Long Point Outdoor Amenity Enhancement Project

Stage 1 Road Safety Audit

Galway County Council

August 2024

Figure 8: Extract from Figure B1 'proposed improved Long Point access junction on R351 and car park'

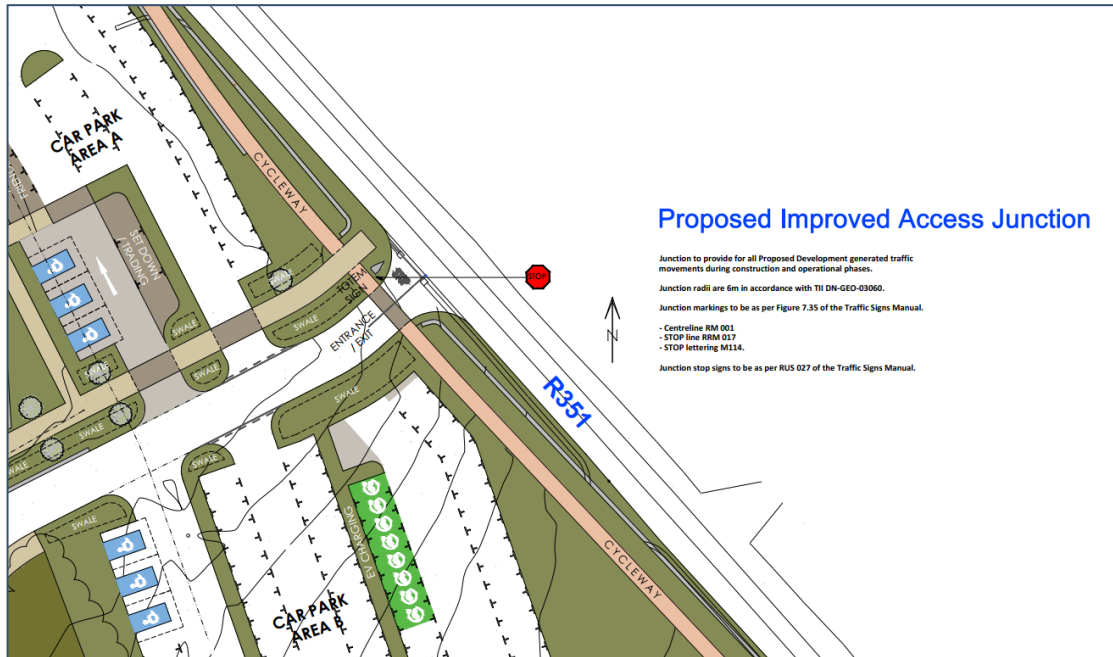
2.2 Problem: Up-Hill Gradient at Connection to Regional Road

Location: Main Vehicle Access Connection to Regional Road R351

The unusually steep uphill gradient could lead to vehicles either rolling back or stalling as they attempt to join the R351. This is likely to increase the risk of a collision at the car park access.

A suitable dwell area (i.e. a short section of road in advance of the stop line where the gradient has been reduced) should be provided on approach to the connection point to the R351 Regional Road.

2.2	Yes	Yes	An appropriate dwell area of 7m with a maximum gradient of 2% will be provided in accordance with Recommendations for Site Development Works.	Designer comment noted & accepted.

Figure B3 Proposed improved Long Point access junction on R351 – visibility in vertical plane

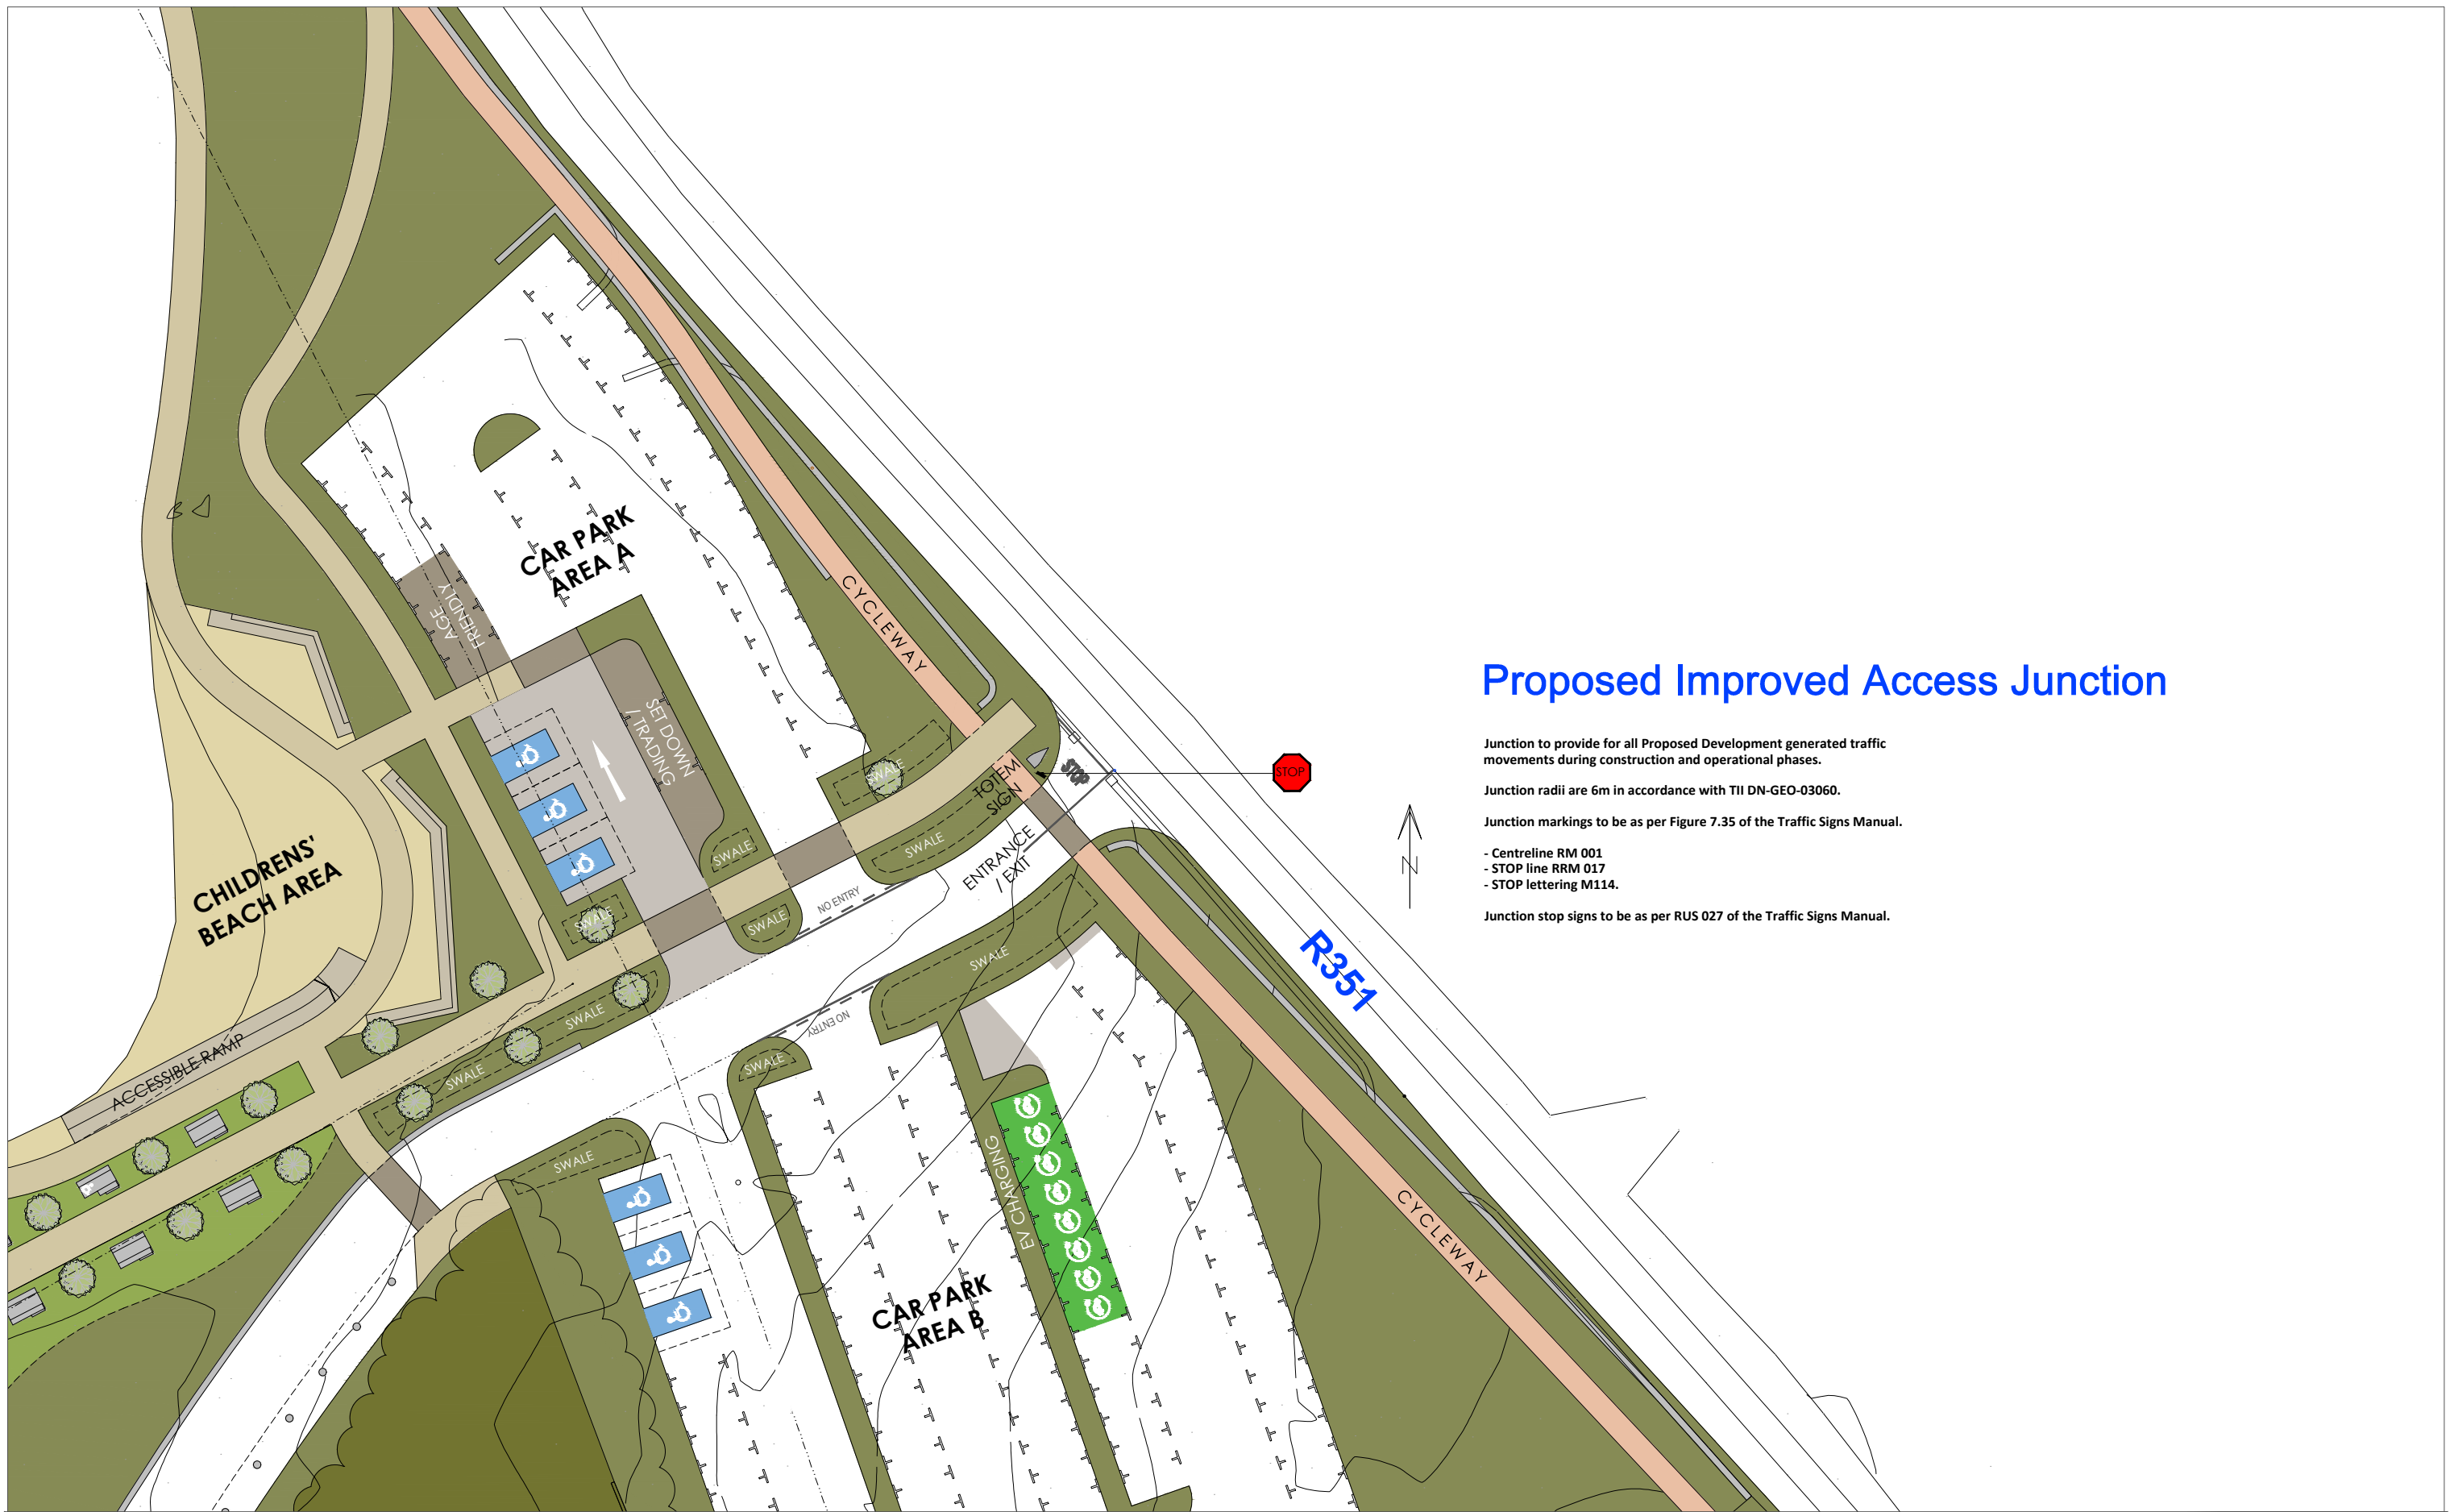
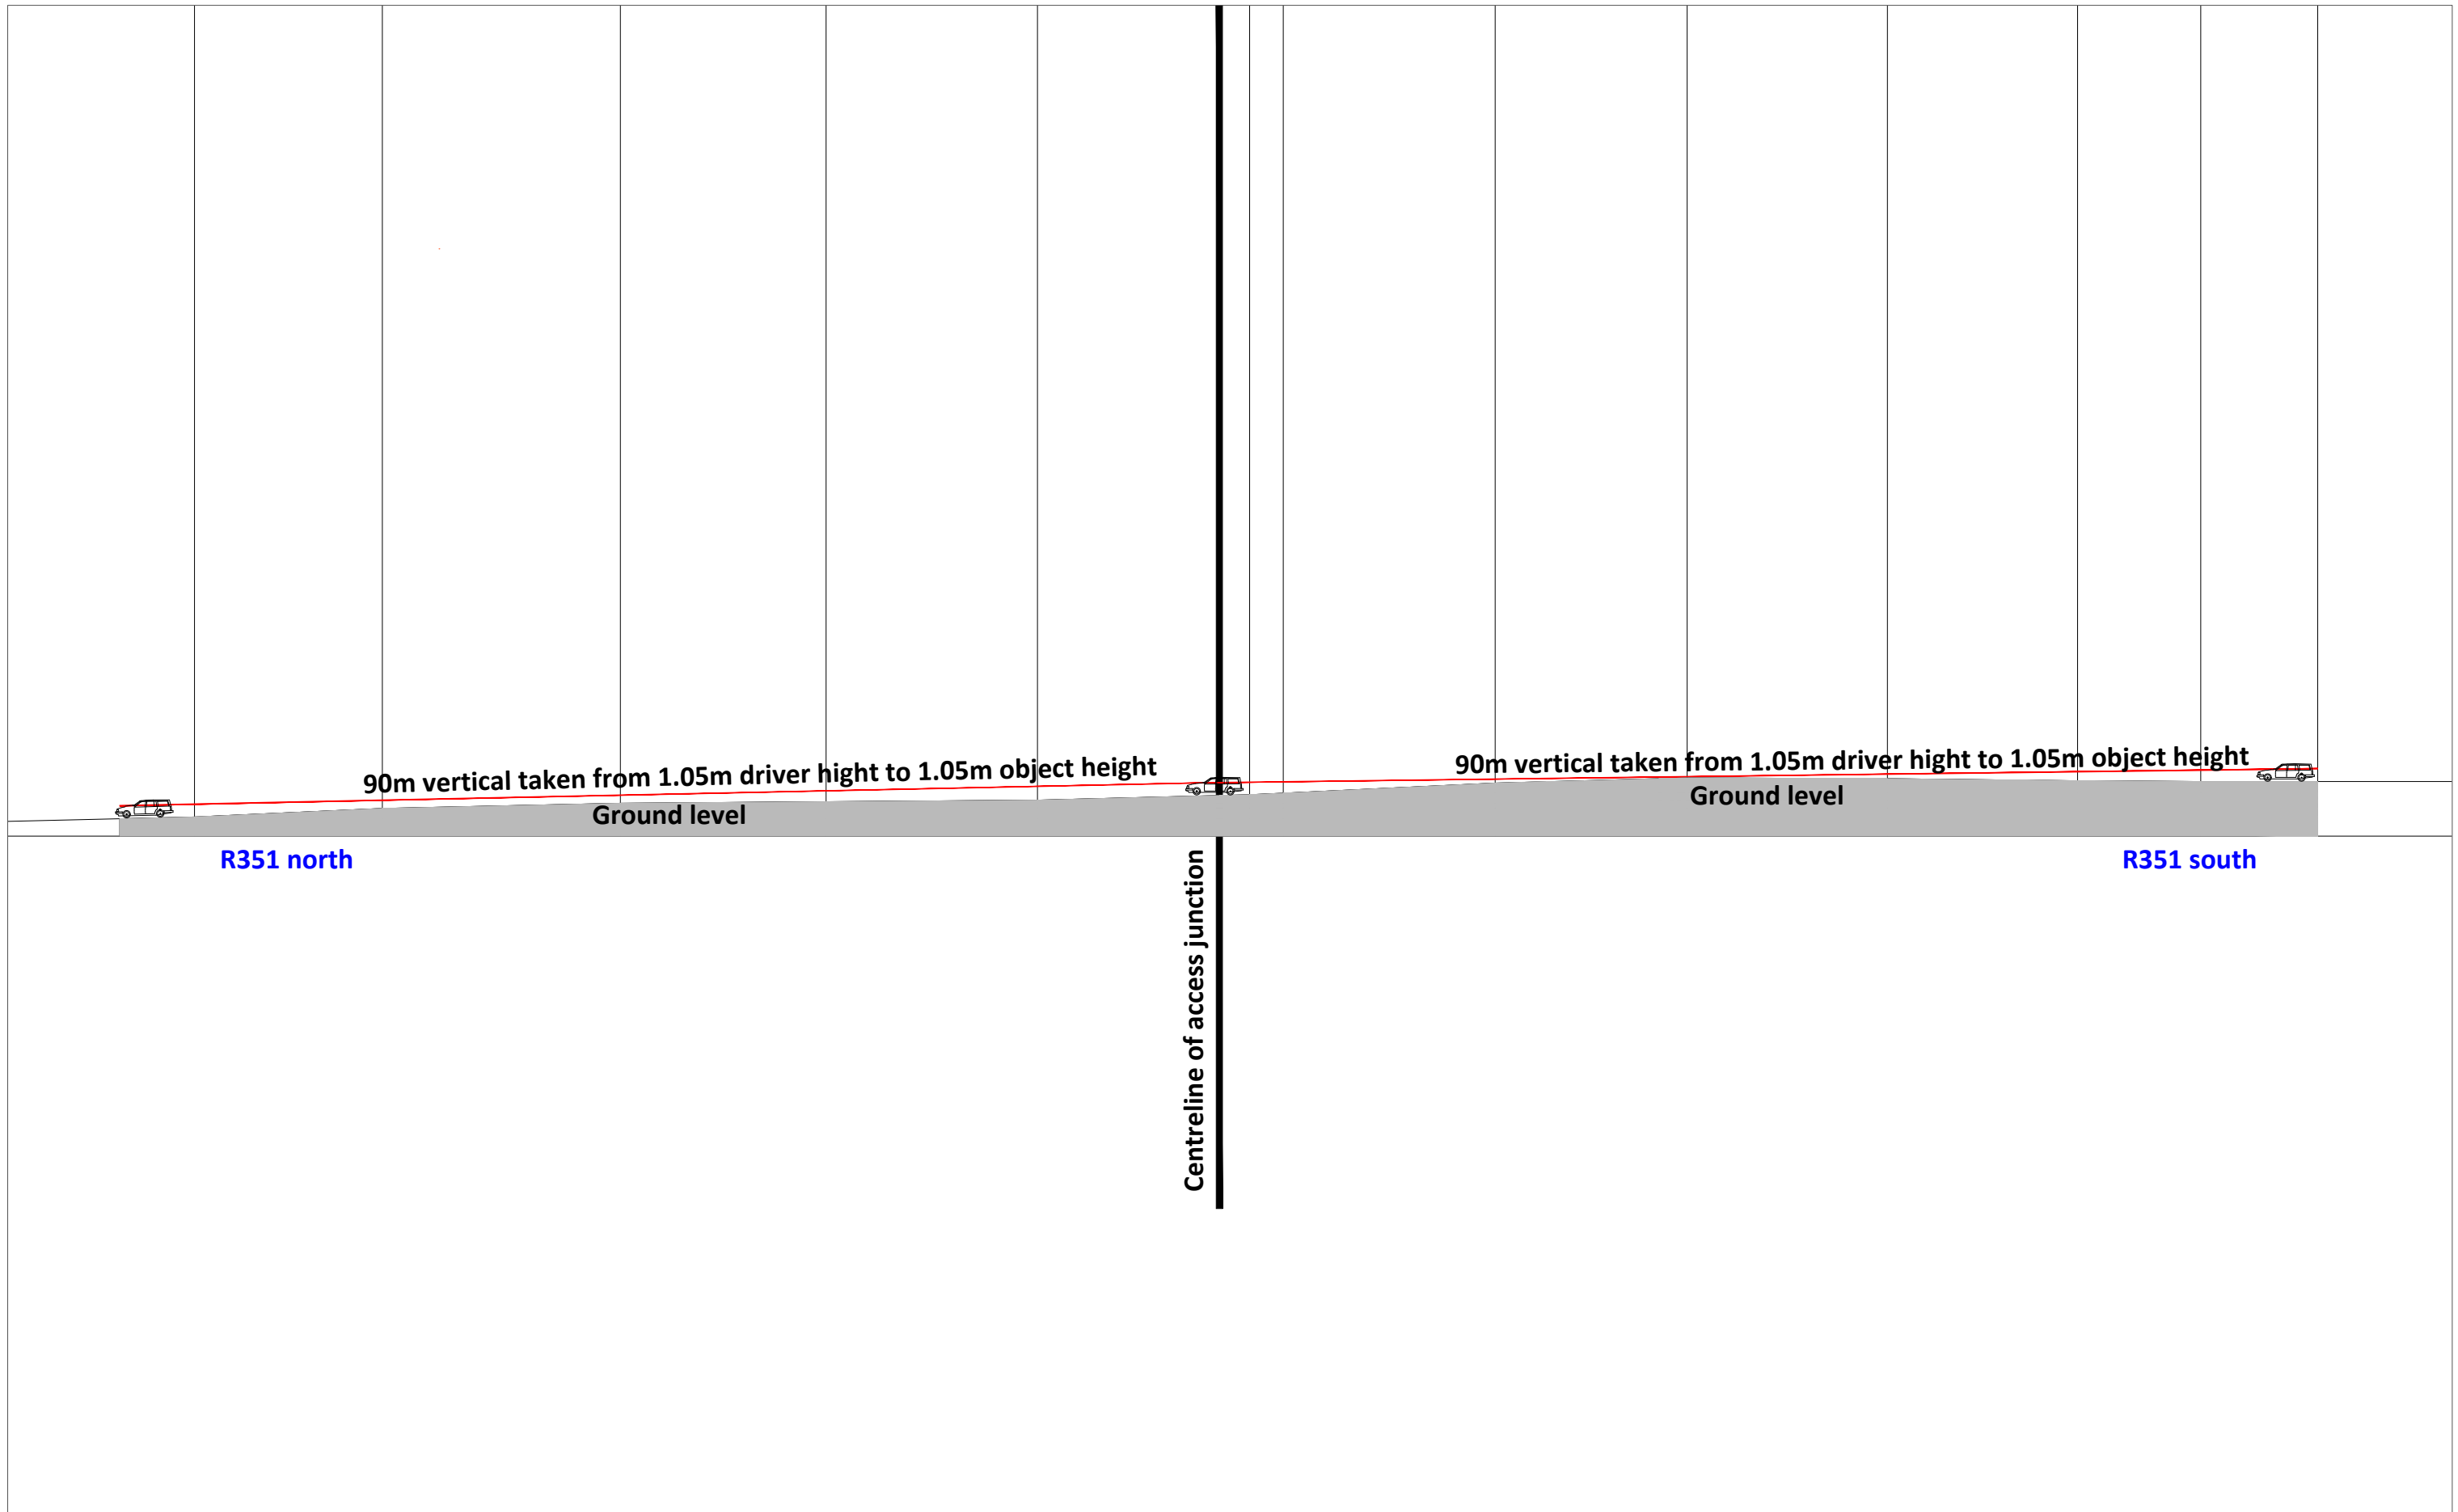
2.1 Problem: Driver’s Sight Line to Right at New Access

Location: Improved Access onto R351

The sight line for emerging driver’s looking to the right appears to be partially obscured by a crest in the road. This could mask the presence of an approaching vehicle, which might lead to an increase in the risk of a collision at the car park access.

Drivers should be provided with an appropriate envelope of visibility at the location described.

2.1	Yes	Yes	It is acknowledged that there is a crest in the R351 to the right (south) of the proposed car park access. For this reason a detailed assessment of the visibility in the vertical plane was undertaken, as shown in Figure B3 provided. The figure demonstrates that the 90m visibility, appropriate for the 60 kph speed limit, to an object height of 1.05m is available from the proposed access junction, in accordance with DN-GEO-03060 TII Geometric Design of Junctions.	Designer comment noted & accepted.
